12 August 2010

**REQUEST FOR ADDITIONAL INFORMATION
THOMAS STREET CAR PARK MP09_0066**

We write to you on behalf of the applicant, Welles Thomas, in relation to your email dated 23 July 2010 requesting additional information in relation to the proposed redevelopment of the Thomas Street Carpark, Chatswood. Our response is provided below, for ease of reference I have included your original comments (*italics*) with our response under each comment.

June 21, 1 pm (Proposed Solar Access Diagram)

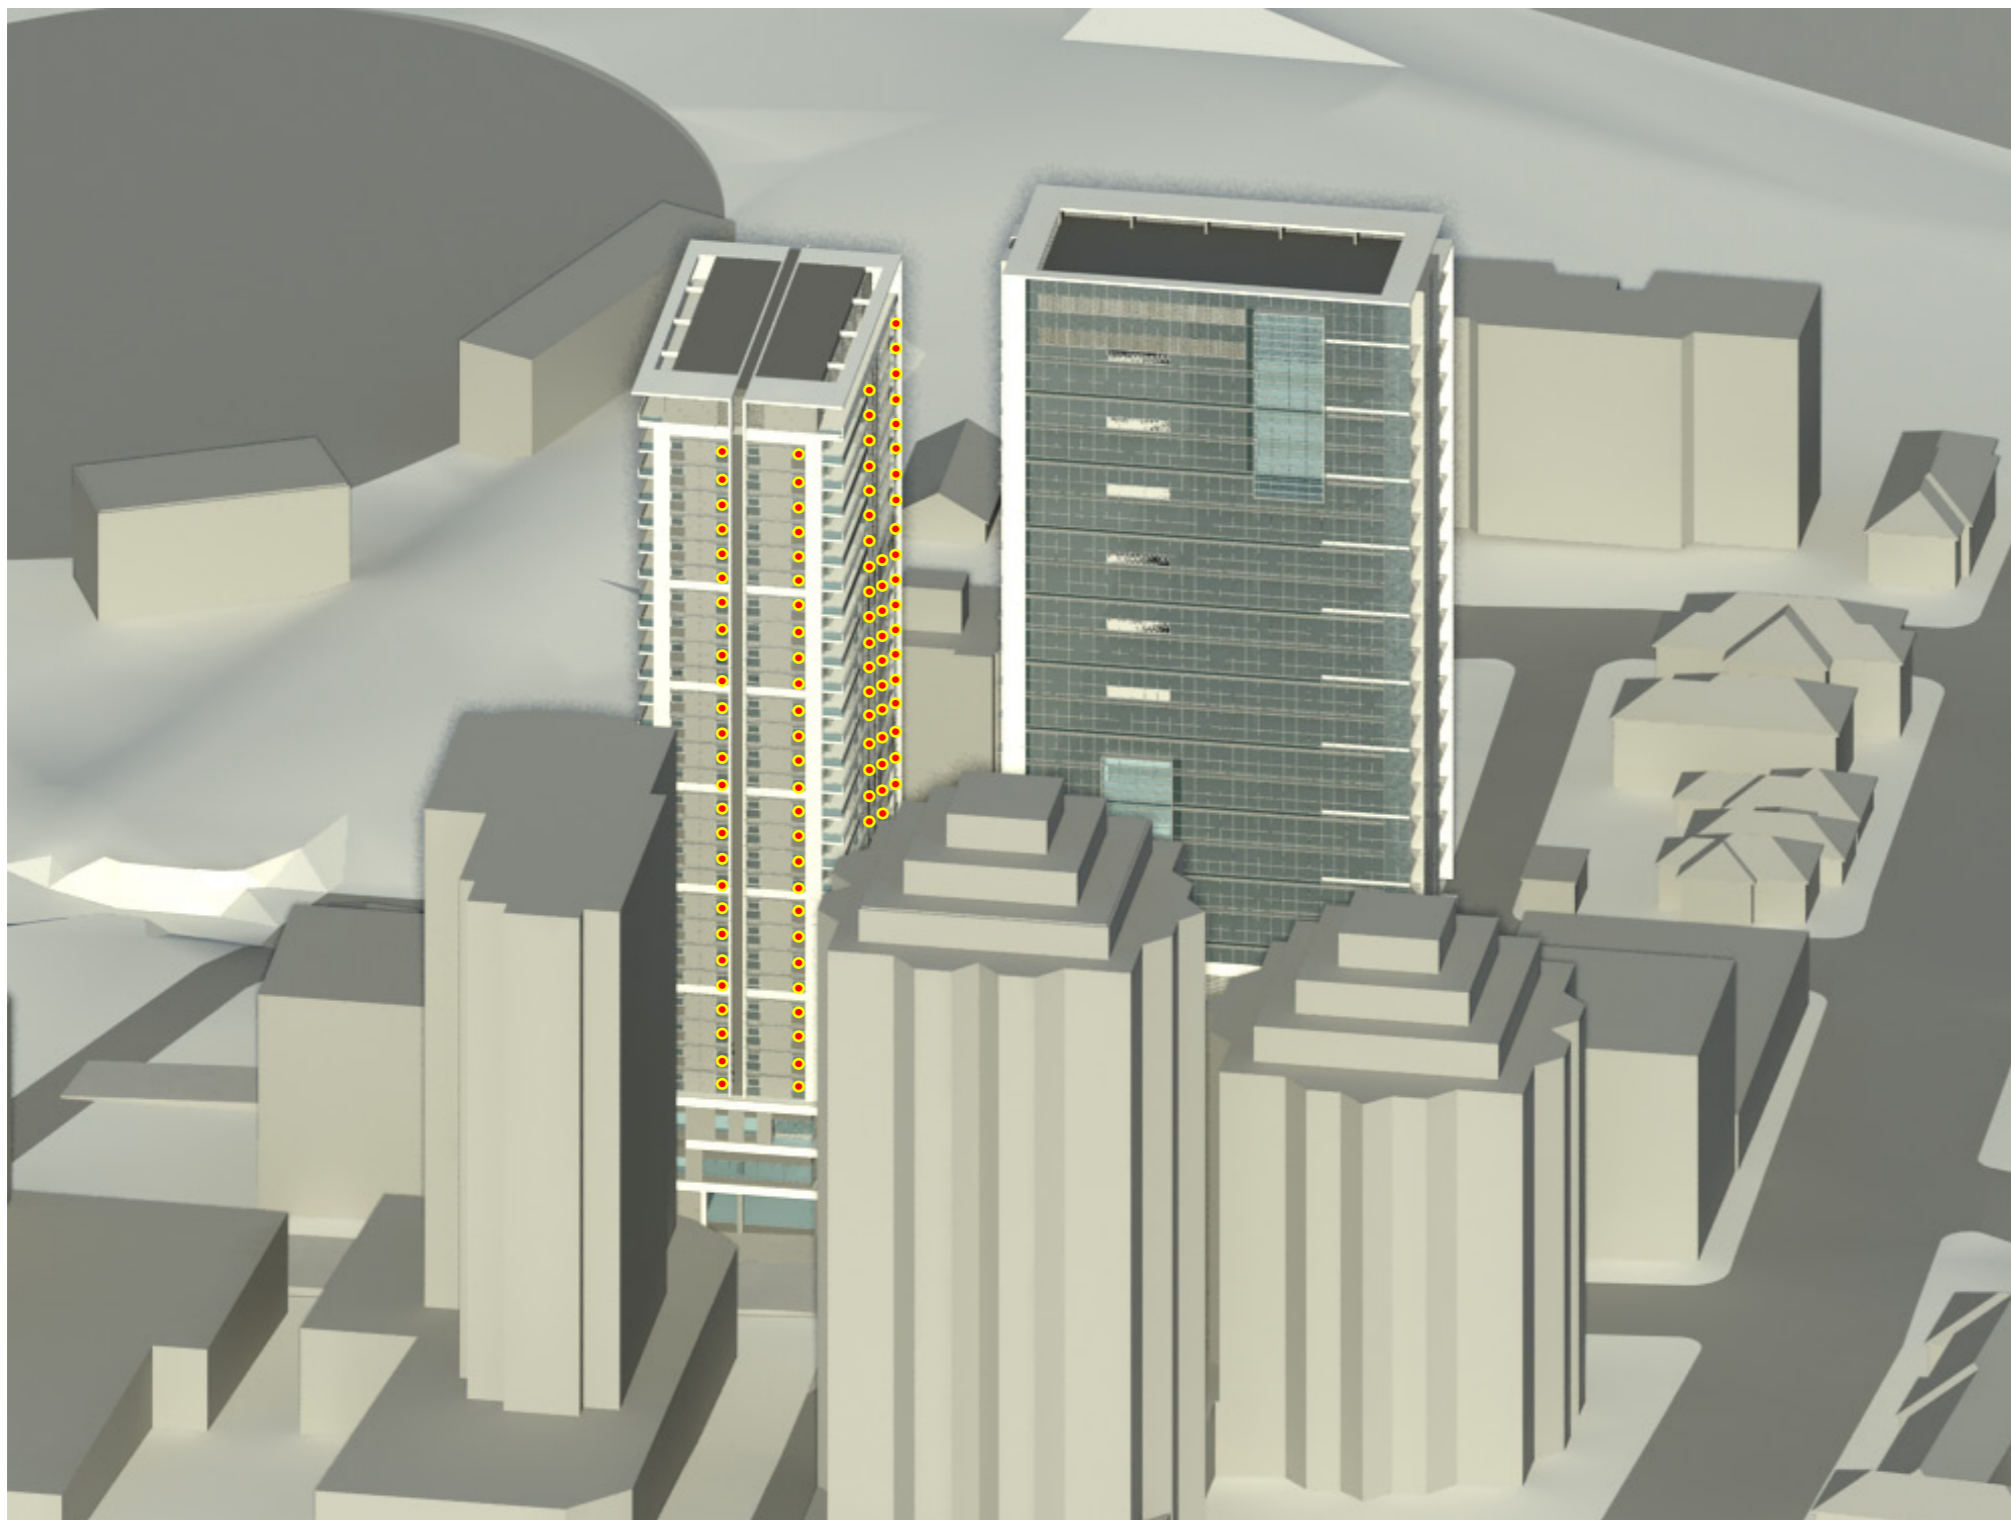
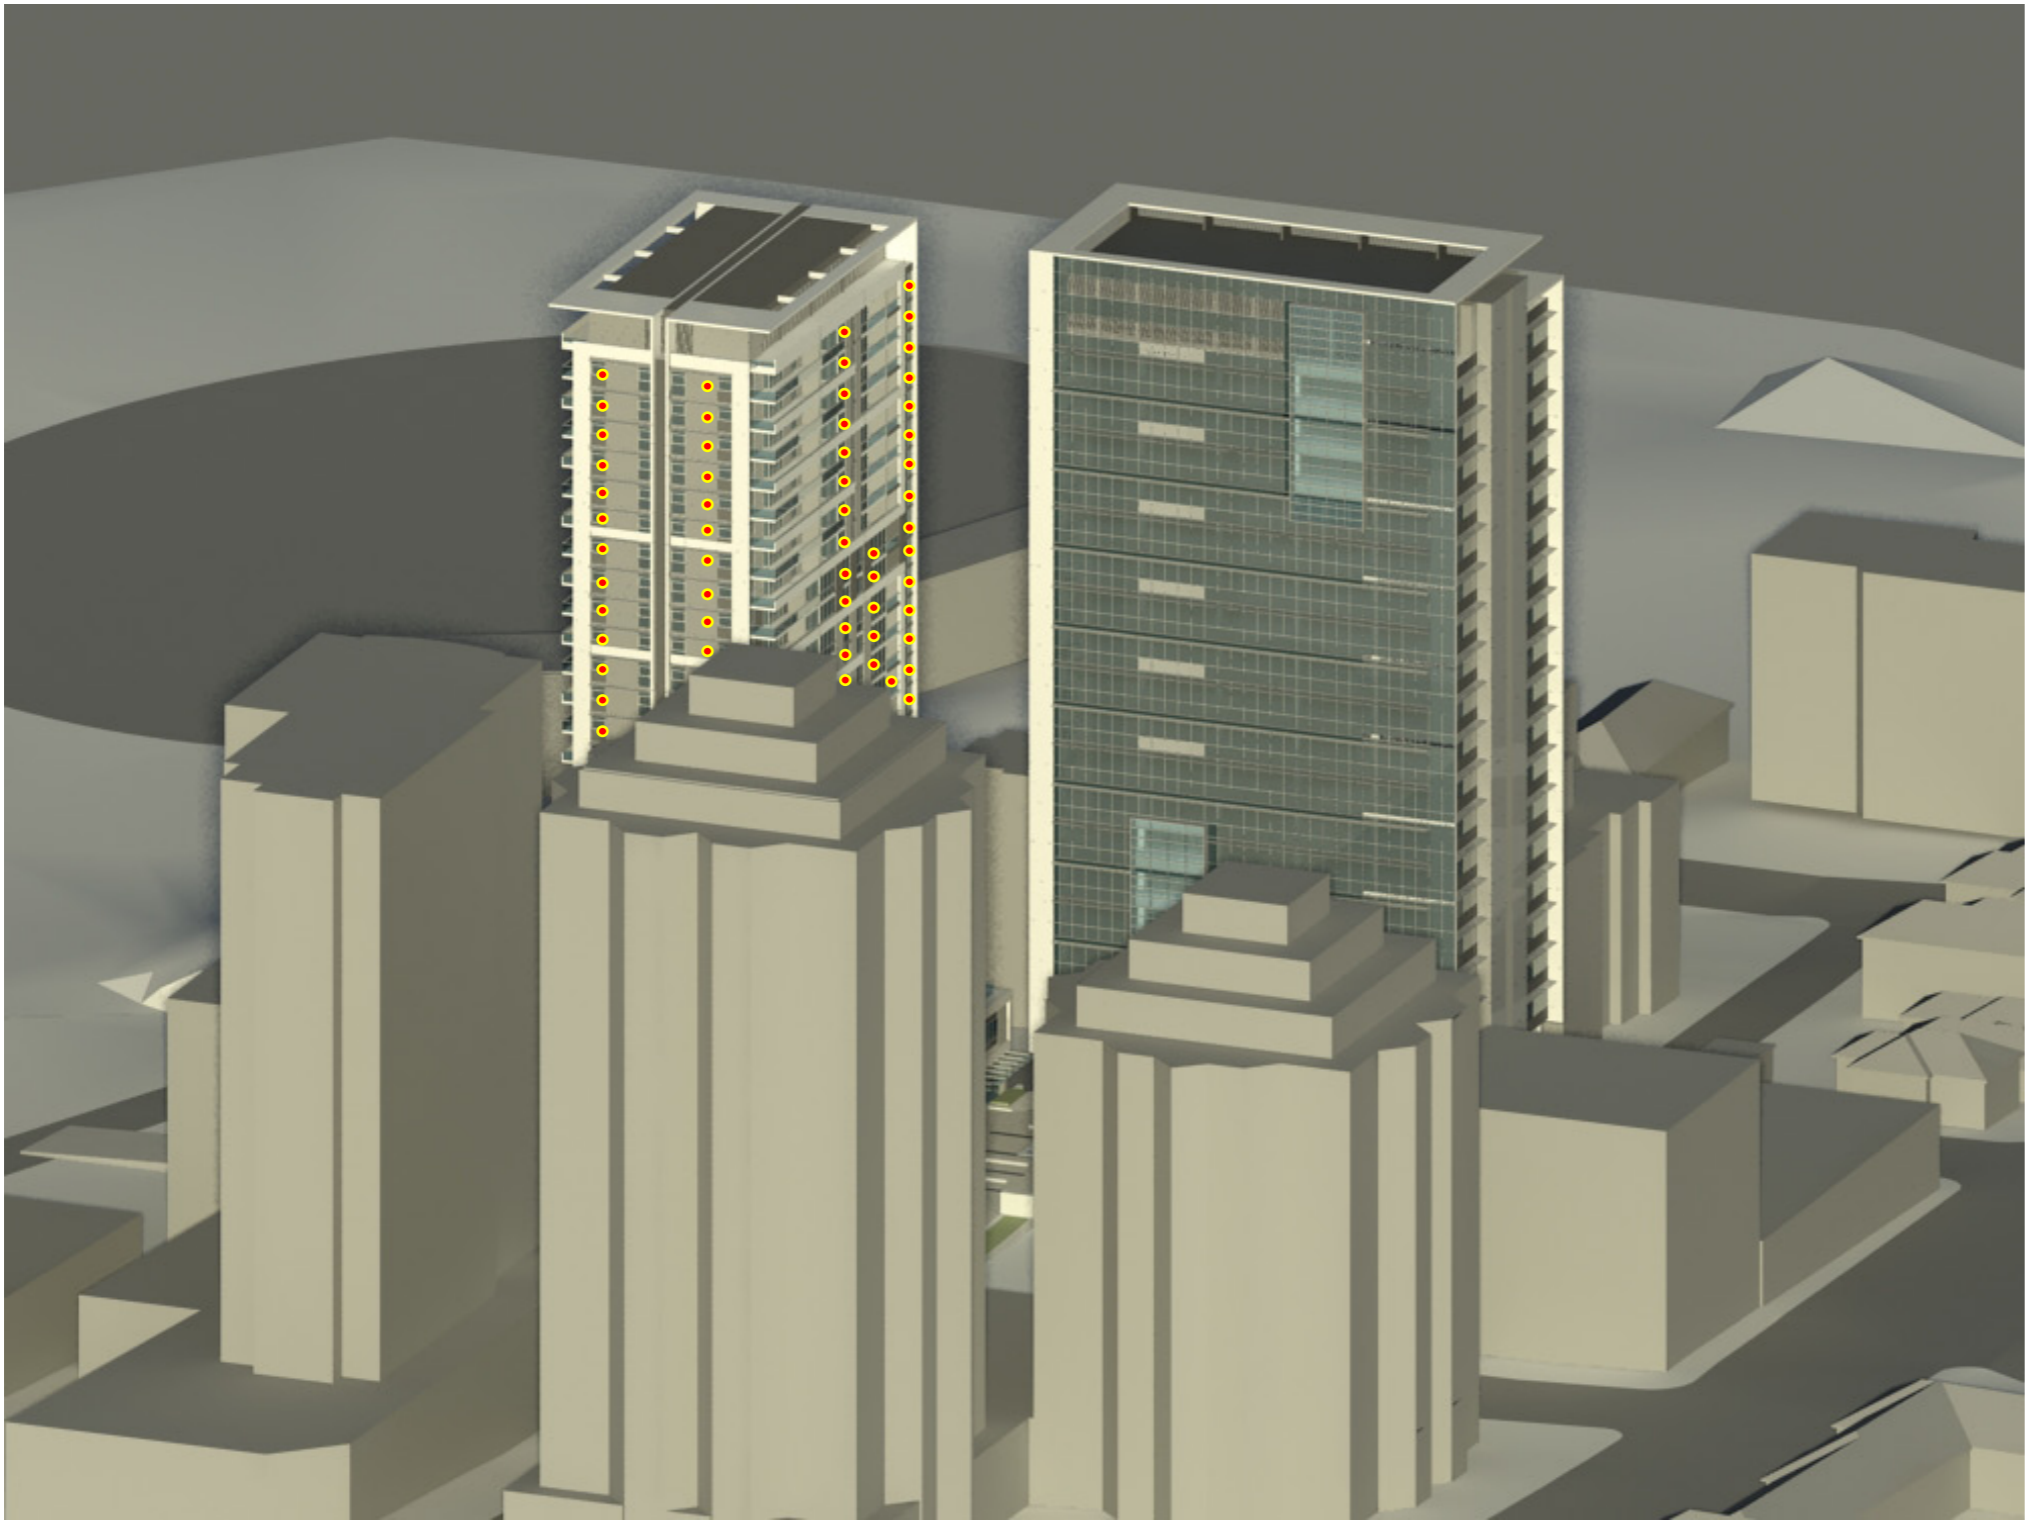
“Further analysis of daylight access for the residential apartments is required. It is noted that only approximate numbers of dwellings achieving solar access and natural ventilation are provided in the PPR. This further analysis should have regard to any overshadowing created by nearby buildings, the reduced number of apartments to 202 and the amendments to levels 3-5 (including louvered screens or any other further amendments to this facade).”

A suns-eye view of the solar analysis to the apartments is provided at **Attachment B**.
